**ADC Planning Consultation
Response from the Historic Buildings Adviser**

Application Number	AB/62/12/L
Address	3 Mount Pleasant, Arundel
Description	Demolition of existing single storey kitchen extension and replacement with single storey extension to provide kitchen, utility and shower room.
Case Officer	James Smith
Site Visit	6 June 2012

Objection

PROPOSED SECTIONS AND ELEVATIONS

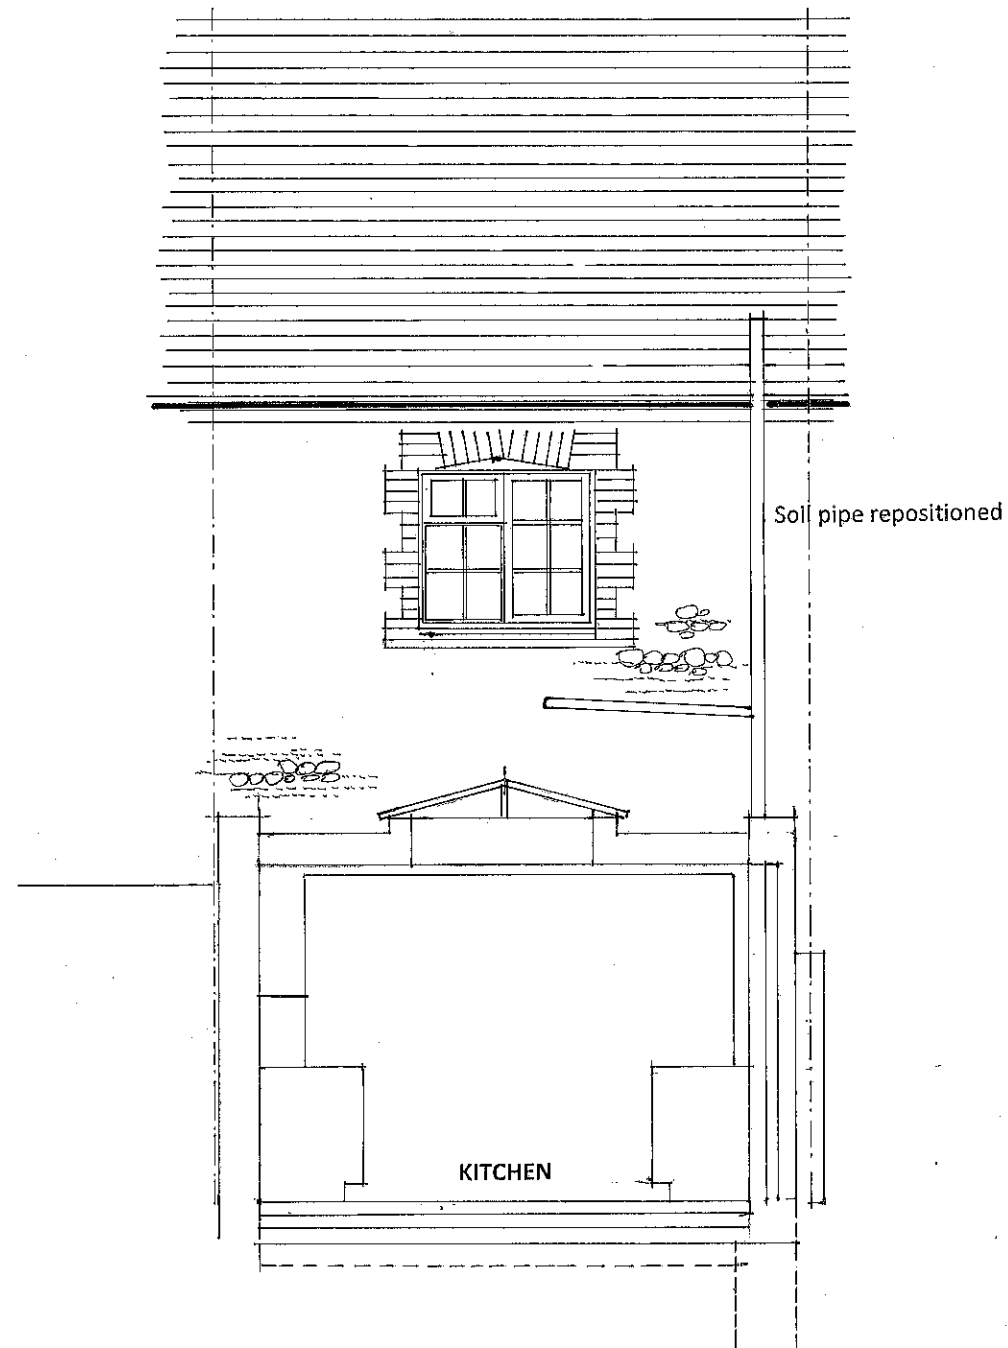
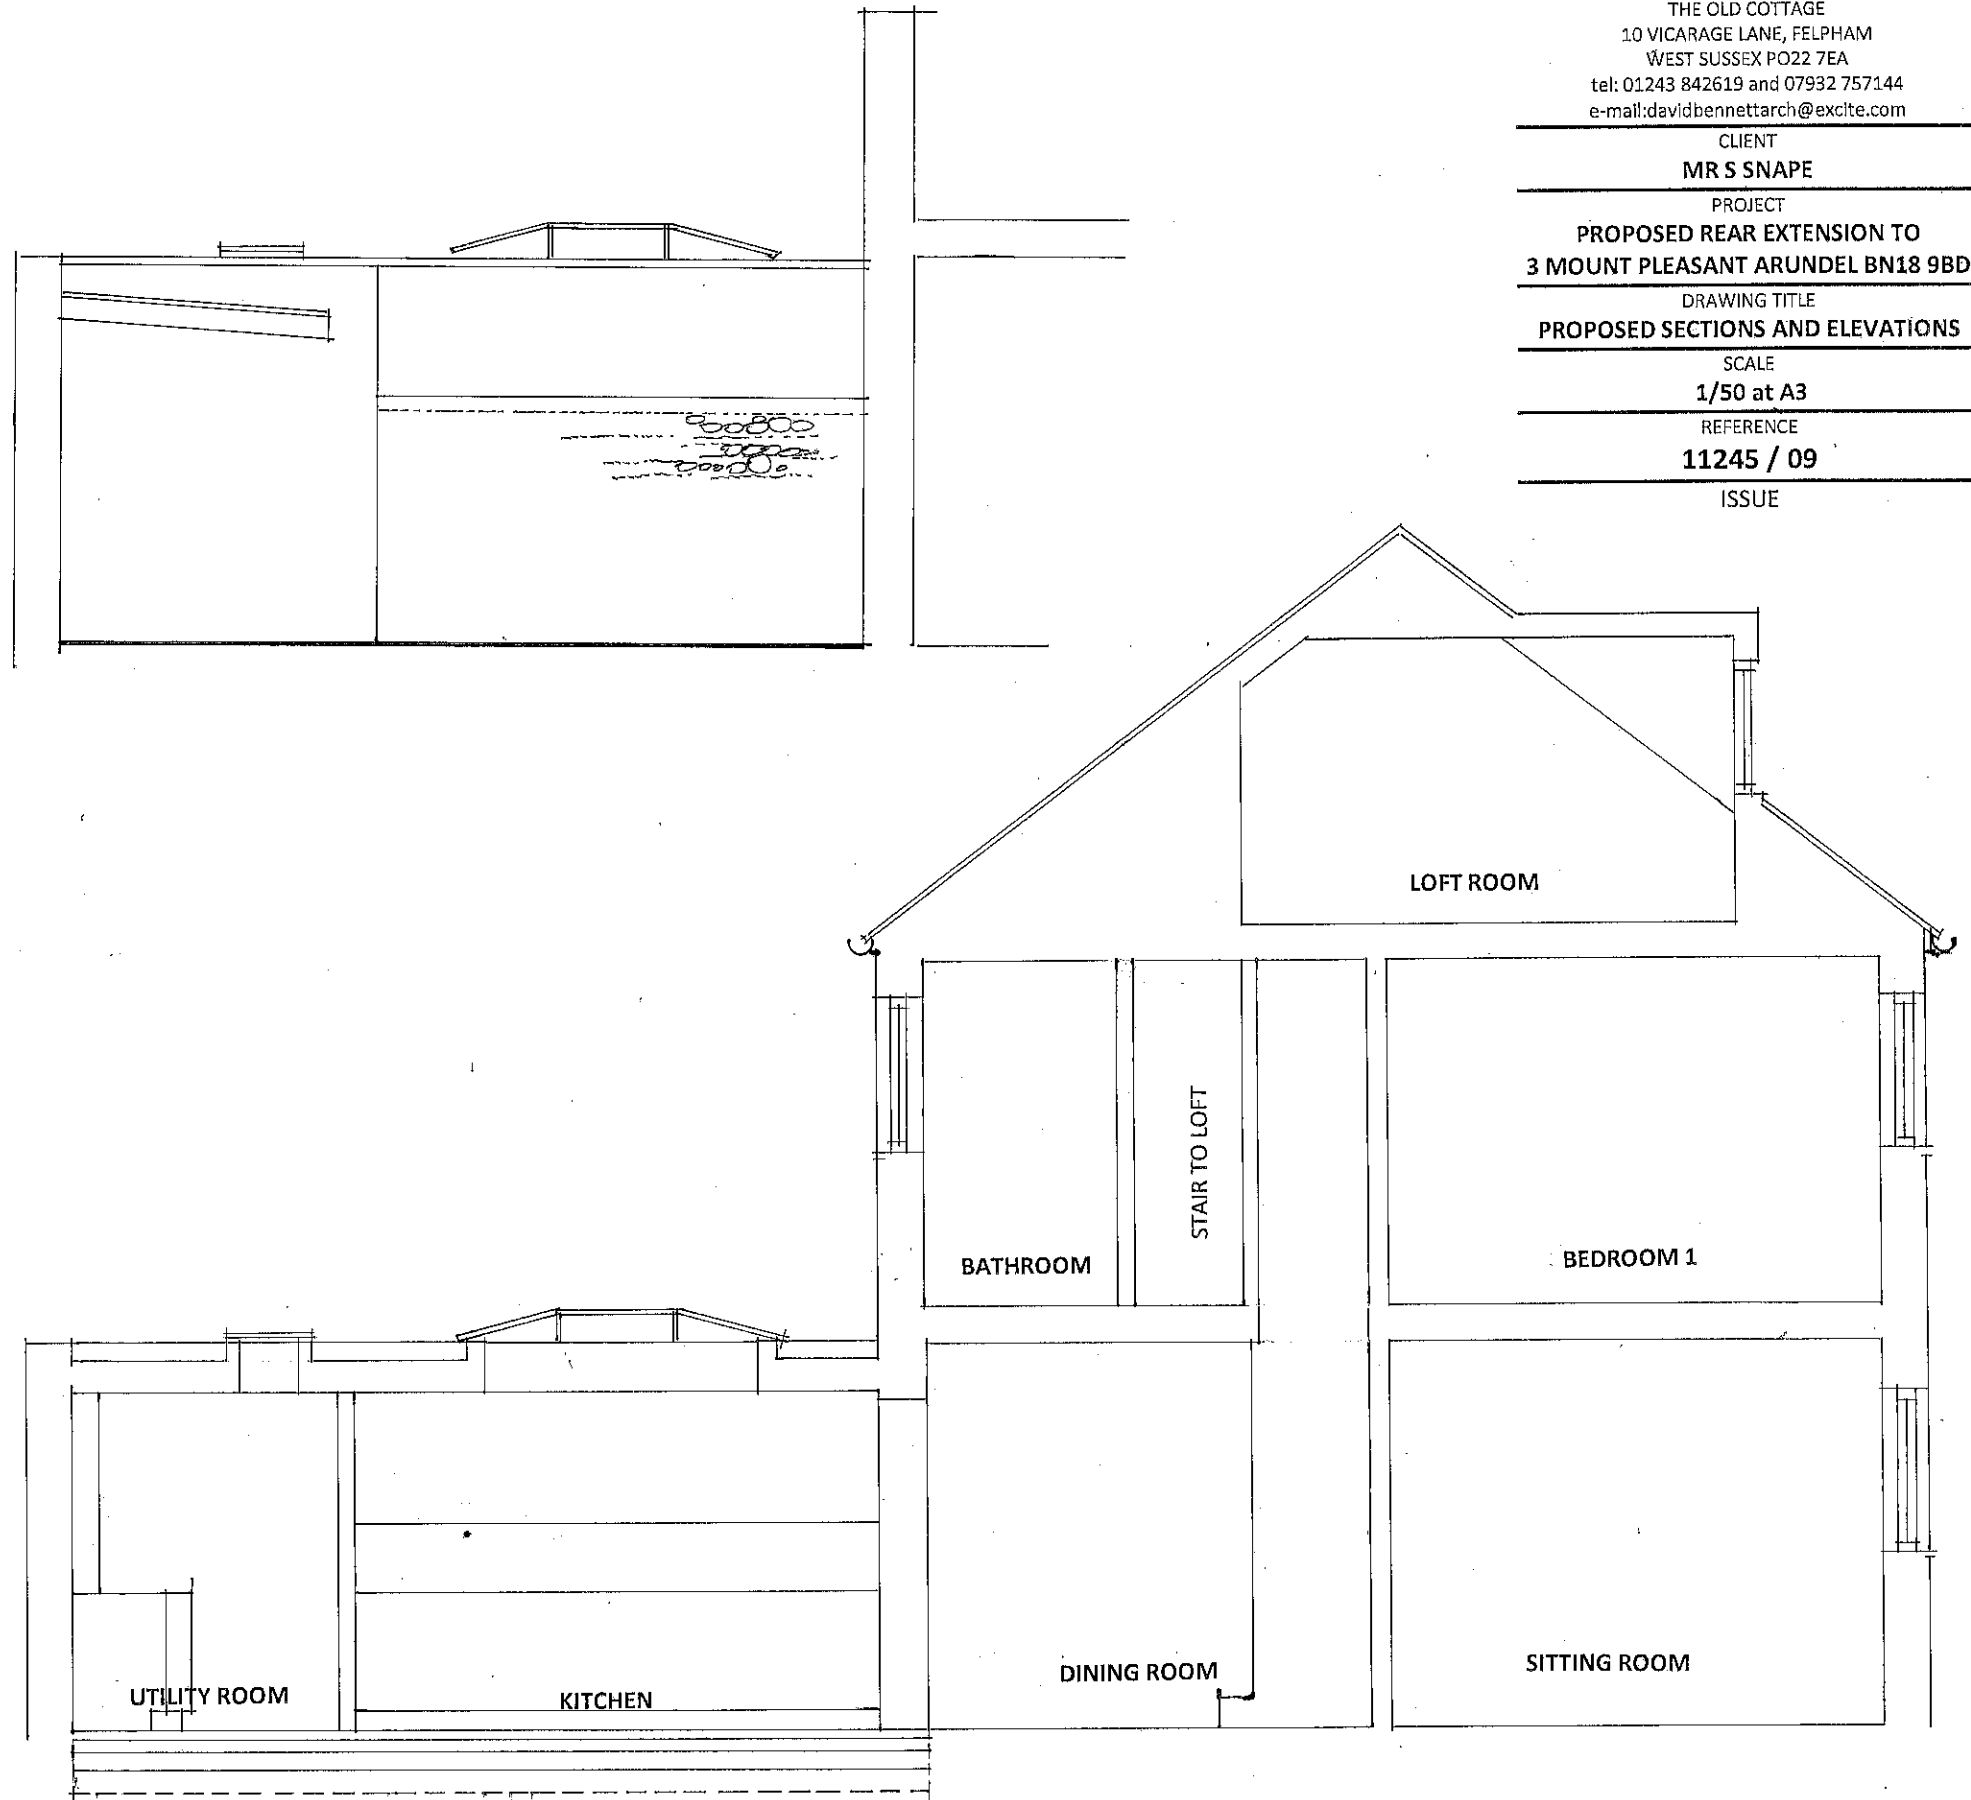
With respect to the extension itself, the addition here is not considered overly detrimental in principle. The addition already takes up most of the courtyard and the space left is very small. The roof profile seems to be an improvement

on the existing mono-pitch roof, but as shown in the 'existing' drawing, does not appear accurate. The pitch seems to be greater than that shown and in reality covers more of the rear elevation. A drop in the roof level here would be considered positive.

PROPOSED SOUTH AND EAST ELEVATIONS

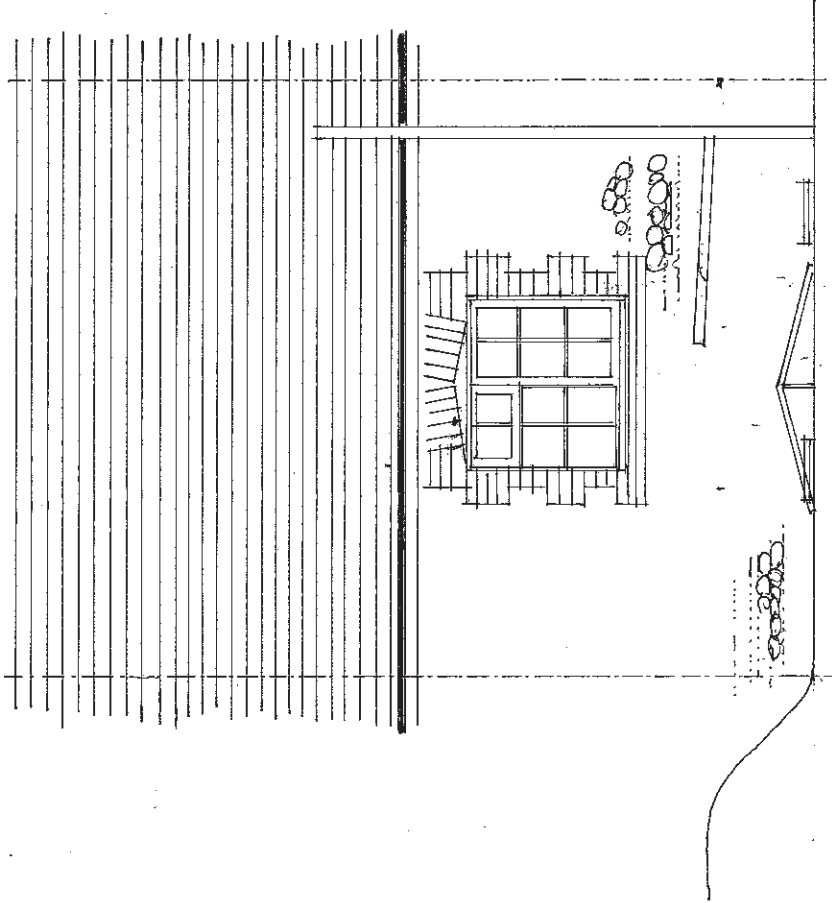
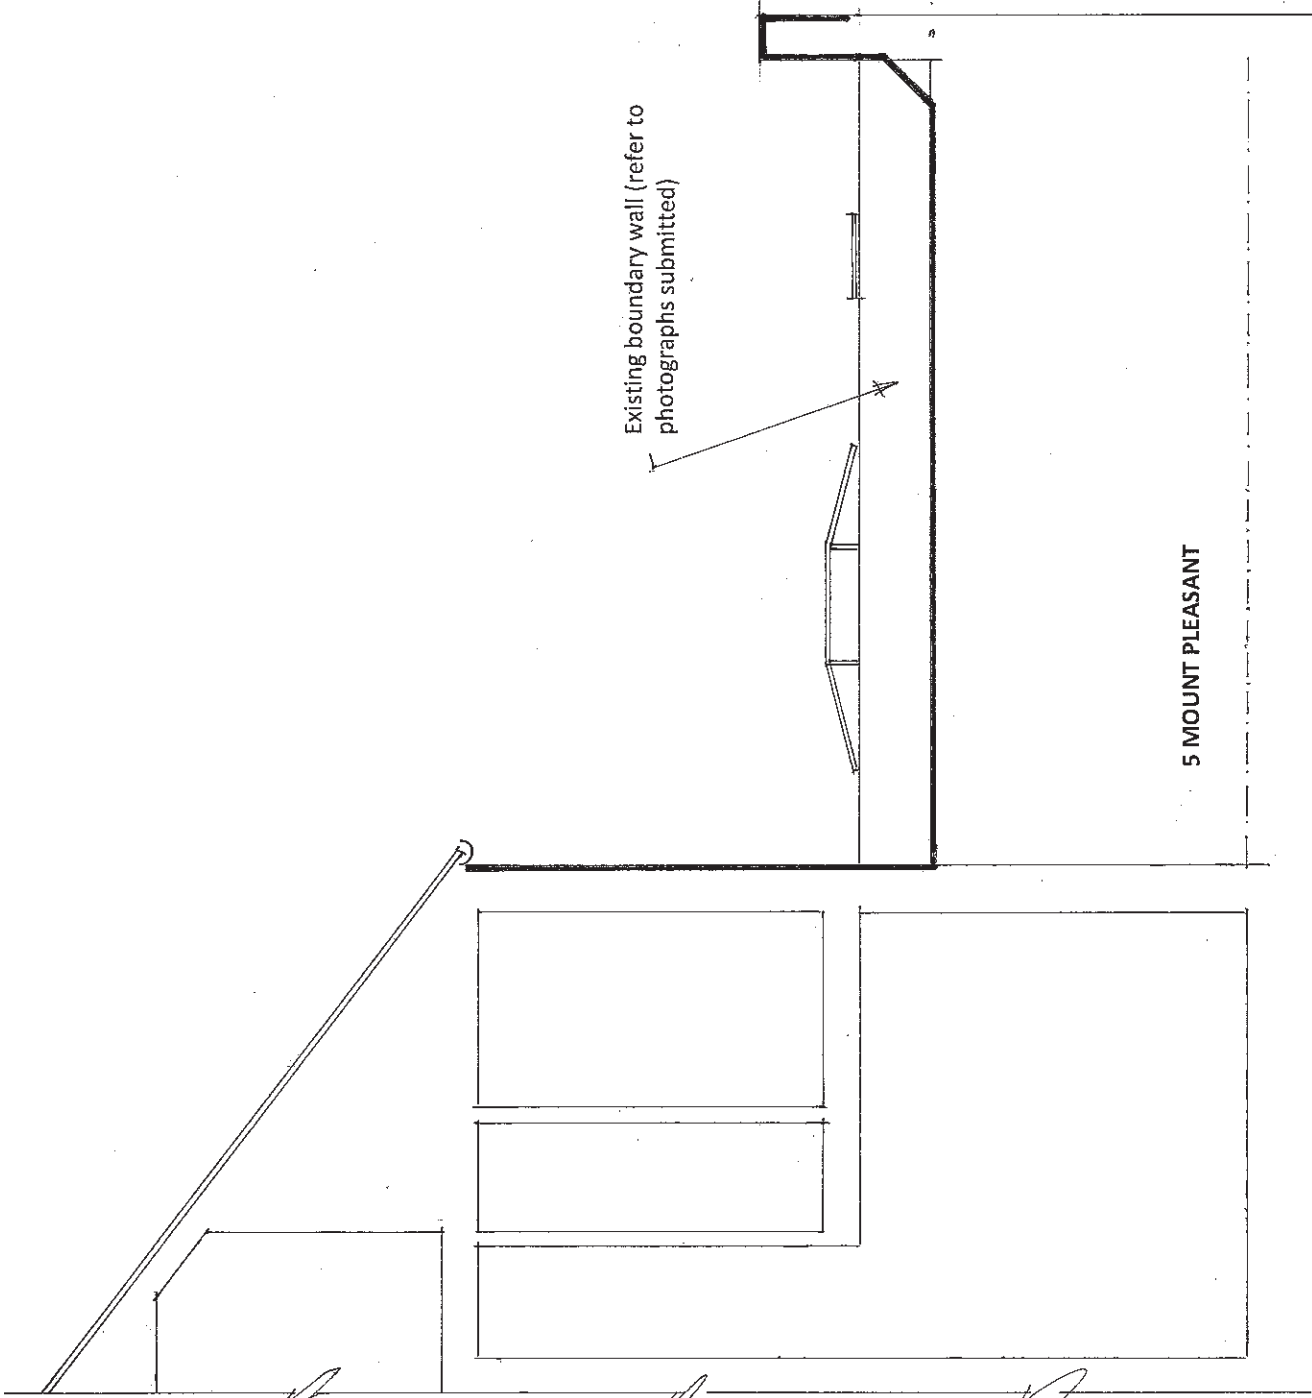
One further concern with the addition would be the detail and construction of the new wall in relation to the existing historic garden wall. We would want details of the new structure and a methodology of how this would be implemented without harming the historic fabric. This would of course be subject to the rear wall of the cottage being retained.
